Further to the comments made on the application [AB/126/20/HH - 38 Dalloway Road Arundel BN18 9HW] we have reviewed them and would like to highlight the following:

BLOCK PLAN
[proposed]

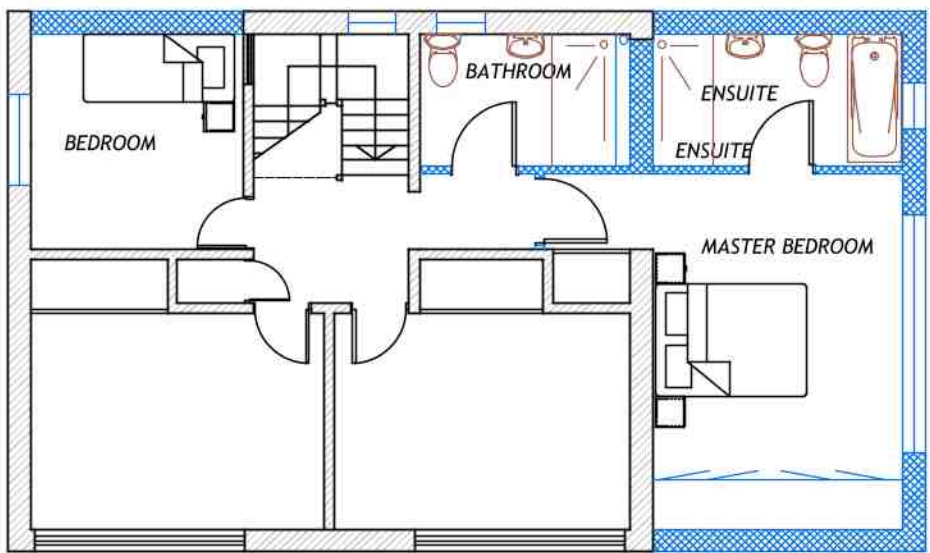
We would like to amend the height of the fence to 1400mm.

FIRST FLOOR PLAN
[proposed]

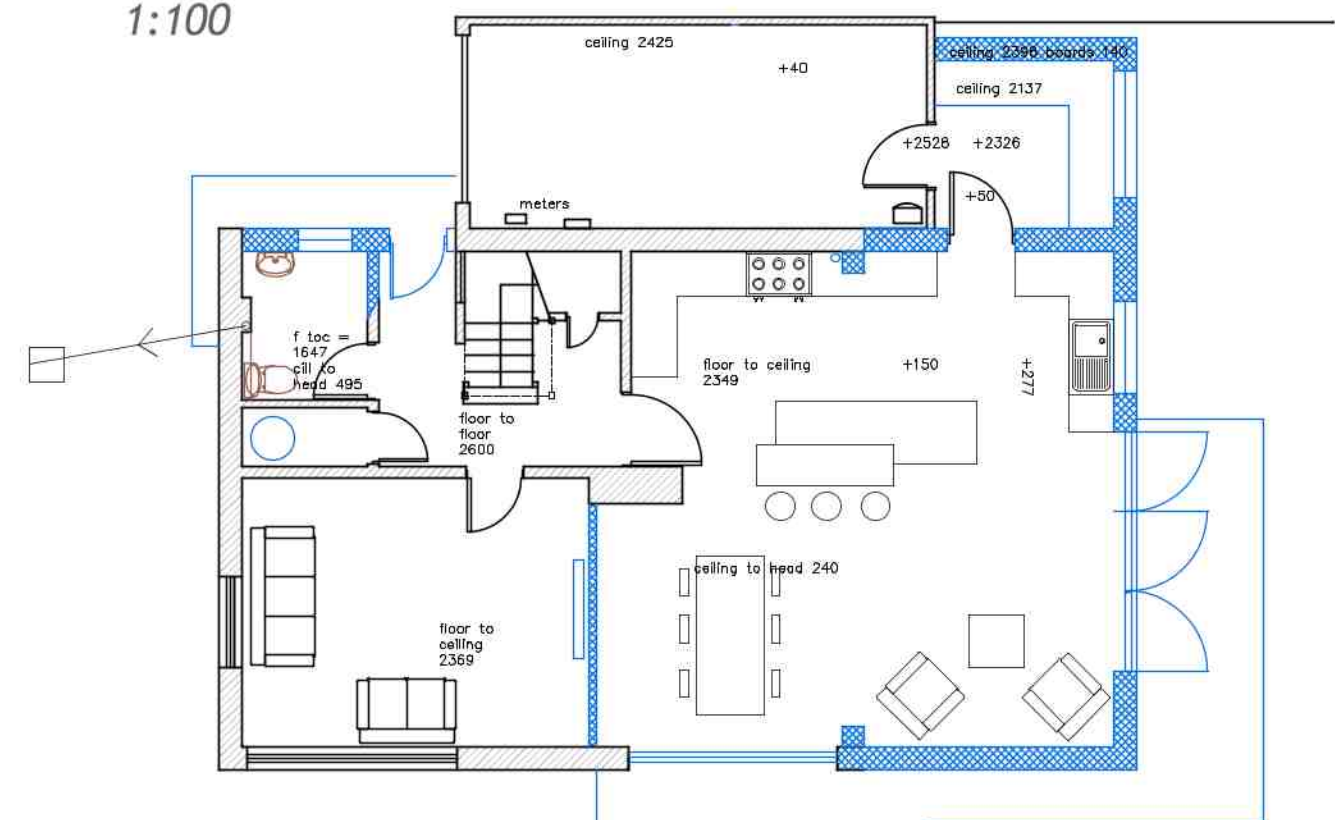
As the above plan illustrates the 2 storey section is away from the boundary from no. 40. It is also only fractionally larger than the PD depth. We feel that it is balanced by the plot. Furthermore, the assessment carried out and photos from no. 40 would have been taken very close to the shortest day of the year and are thus the worst case scenario.

WEST ELEVATION
[proposed]

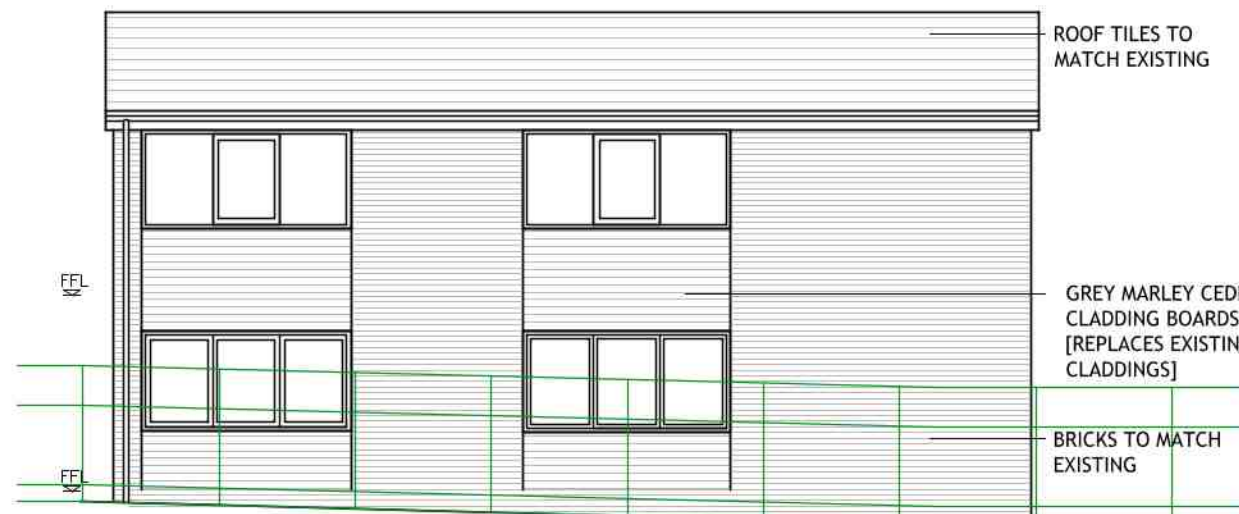
As the above elevation illustrates the new windows are to non habitable room. The bathroom window can be fixed shut and frosted to eye level. The landing window is considerably about eye level as it is above the half landing – therefore it will not be possible to stand next to it and peer out – however, if the planning department feels this is an issue this too can be frosted and fixed shut to match the bathroom
